From: Kathryn Welch
Sent: 07 April 2026 13:22
To: [REDACTED]
Subject: AW/42/26/PL

Following some initial investigation and a review of the submitted plans and supporting documents, it has come to my attention that one of the trees on site; identified as T2, a Silver Birch, is protected under a Tree Preservation Order (TPO). I am not certain whether you were aware that this tree is subject to statutory protection. I also note that the Tree Survey states, in relation to T2, that “*construction of the extension does not specifically require the removal of any trees.*” In light of this, the Authority’s strong preference would be for this protected tree to be retained. We have not yet had comments back from the Arboricultural Officer, he *may* object to the proposal due to this.

PROPOSED SITE PLAN 1:500

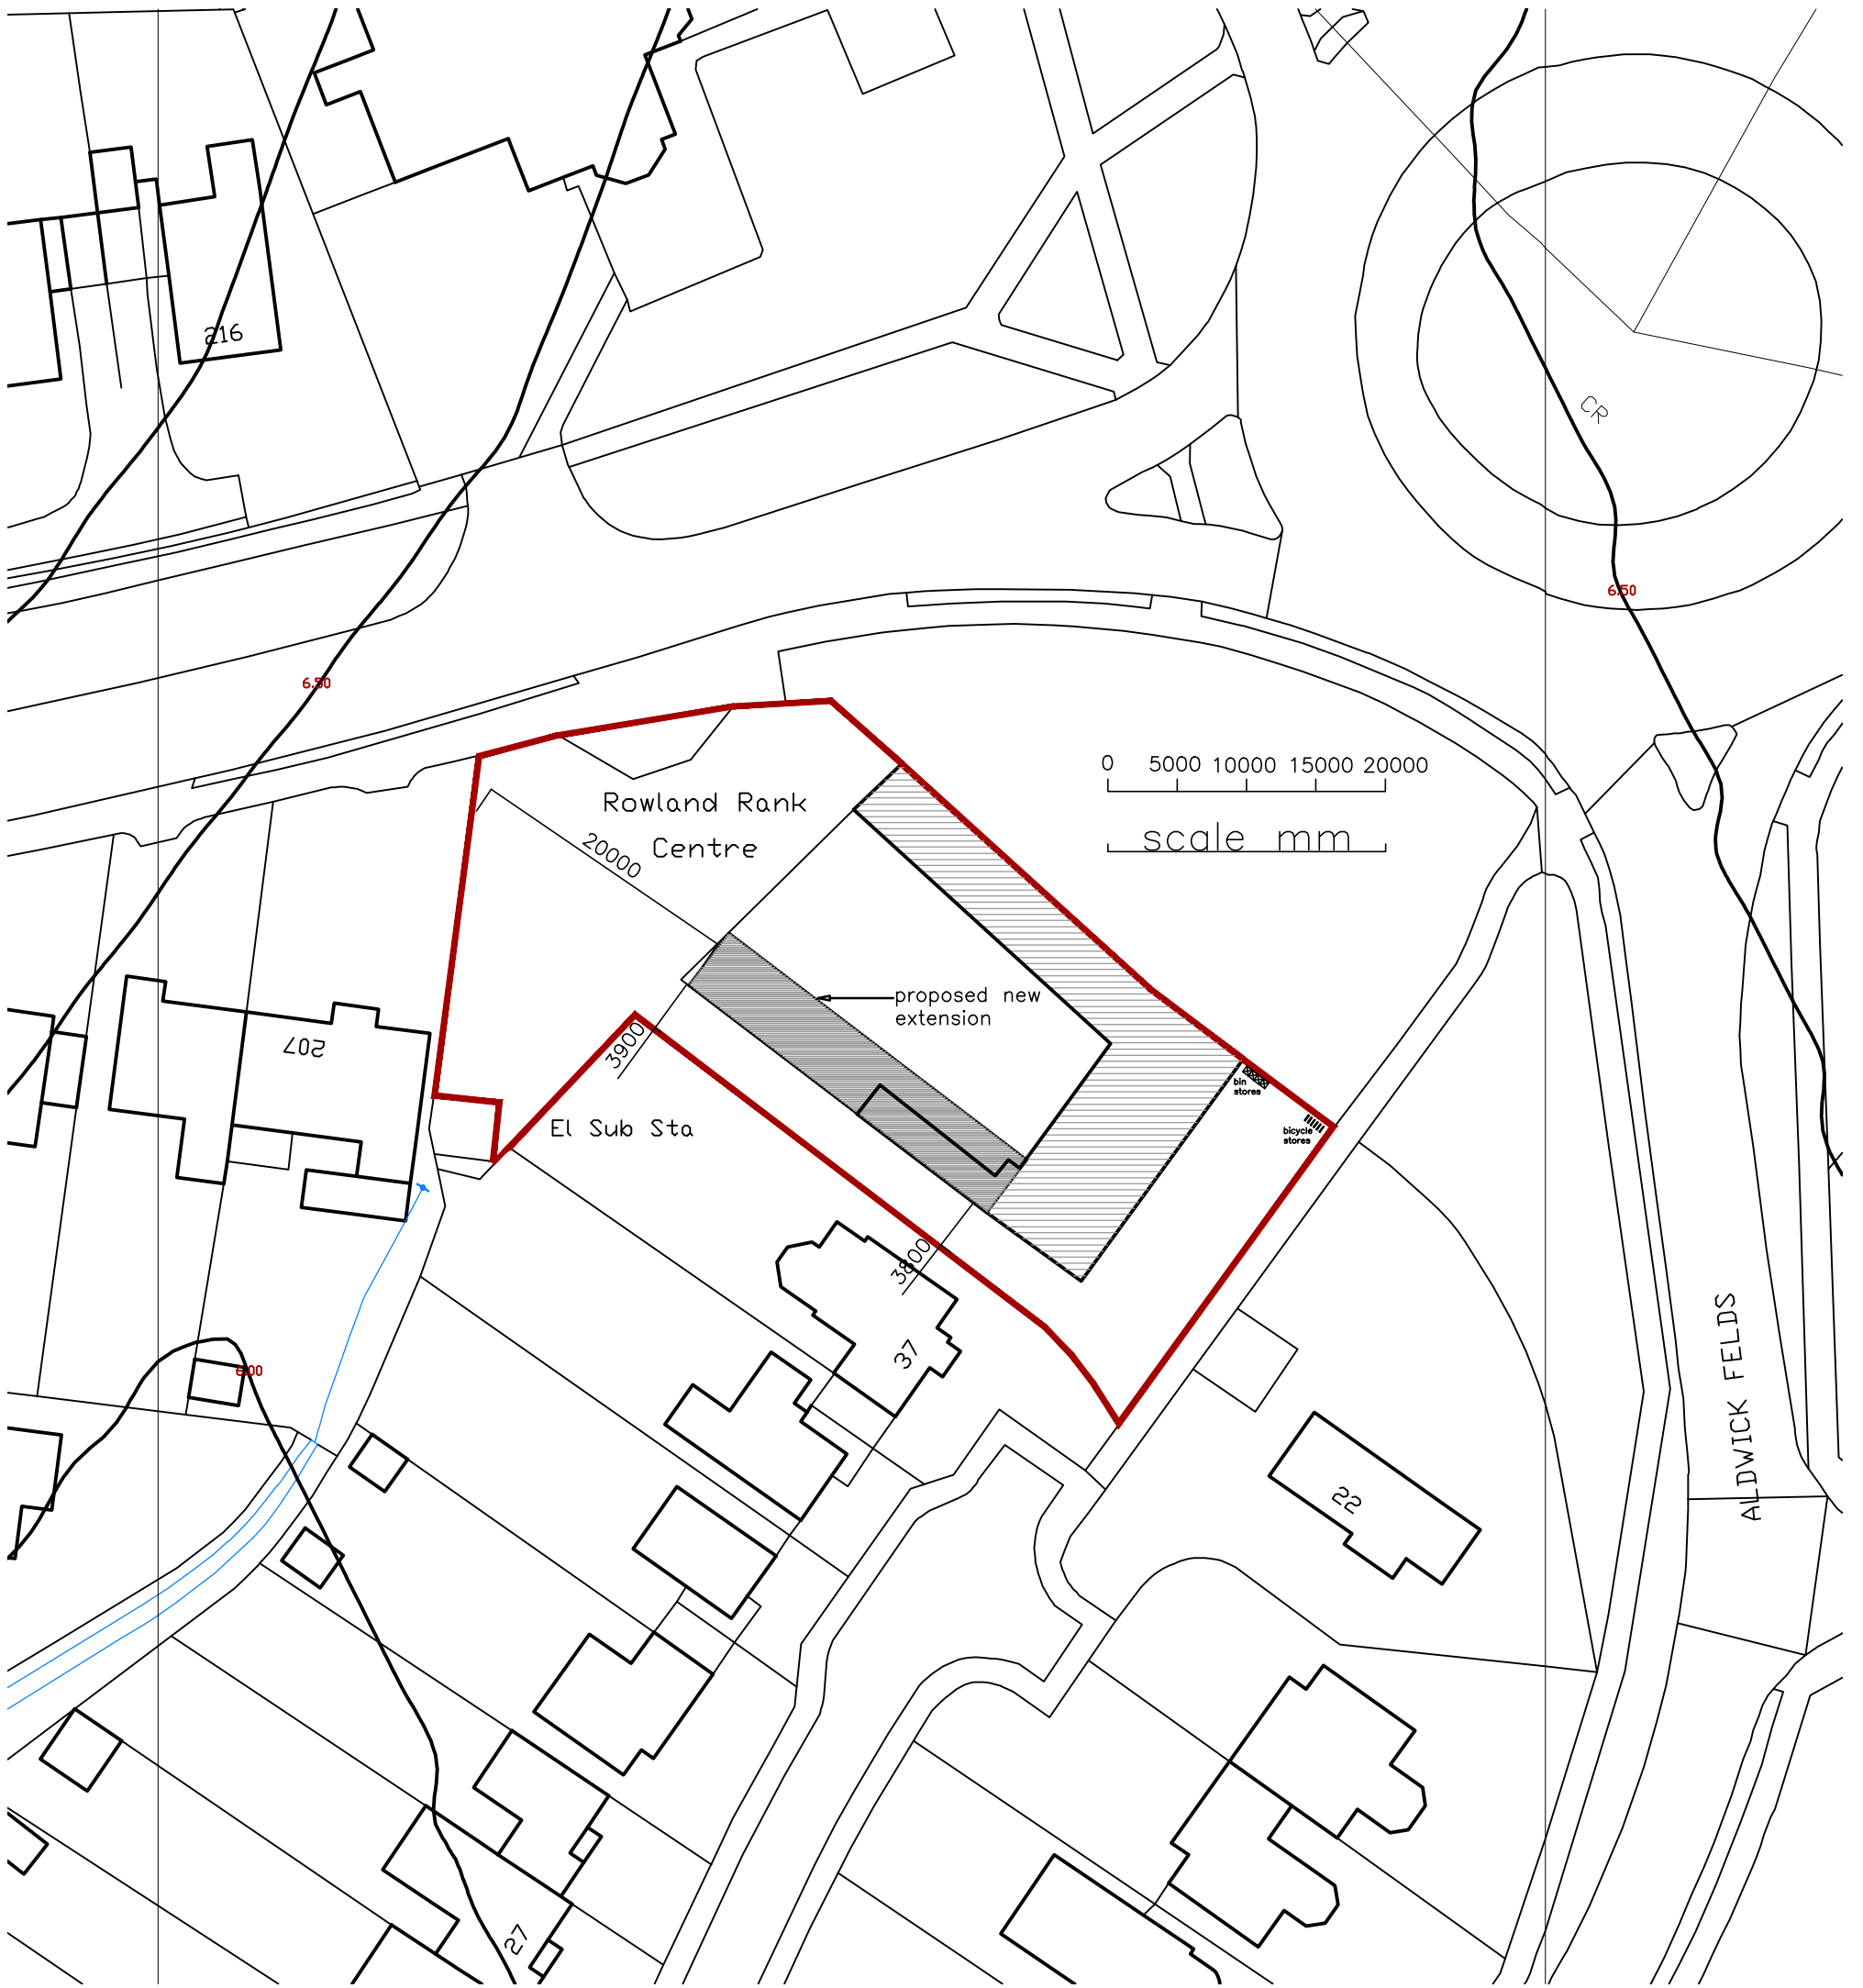
Could you please investigate whether the proposed development can be constructed without the loss of T2, as the Tree Survey suggests may be possible? Any clarification or revised plans demonstrating tree retention would be welcomed. If you could confirm which way you intend to proceed by the end of this week that would be helpful.
